# CITY OF ALBUQUERQUE

**Re: Las Ventanas at San Isidro  
3739 San Isidro NW  
Request Permanent C.O. - Accepted  
Engineer's Stamp Dated 3-23-13 (File: G13D031)  
Certification dated: 7-29-16**

ENGINEER'S SEAL  DAVID SOULE P.E. #14522	LOT 10B1 AND LOT B2 CANDELARIA PLAZA ADDITION	DRAWN BY JDG
	GRADING AND DRAINAGE PLAN	DATE 03-23-06
 Rio Grande Engineering 1606 CENTRAL AVENUE SE SUITE 201 ALBUQUERQUE, NM 87106 (505) 872-0999		SHEET # 1 OF 1
		JOB #

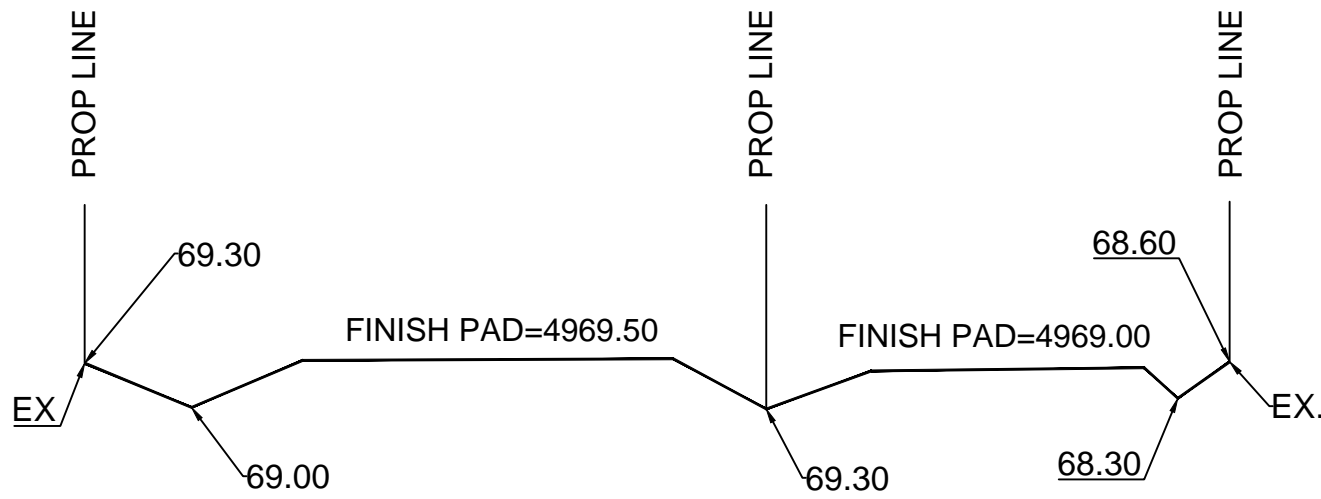
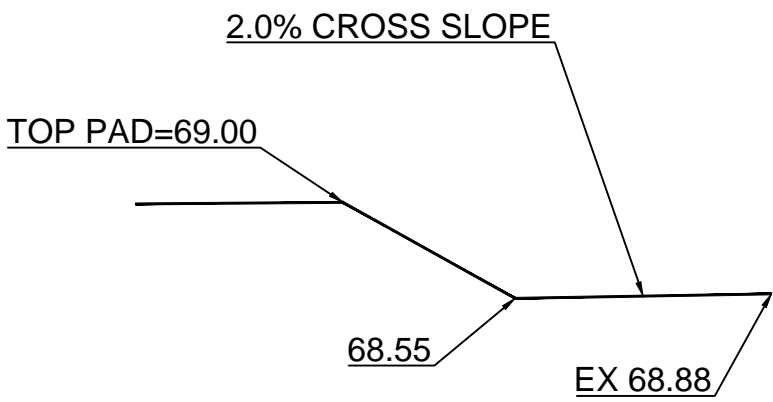
- Both ponds are present however neither is landscaped. During the landscaping phase the integrity of the ponds must be maintained per the City of Albuquerque drainage ordinance.
- The ponds must be stabilized with landscaping within 90 days from the date of this letter.
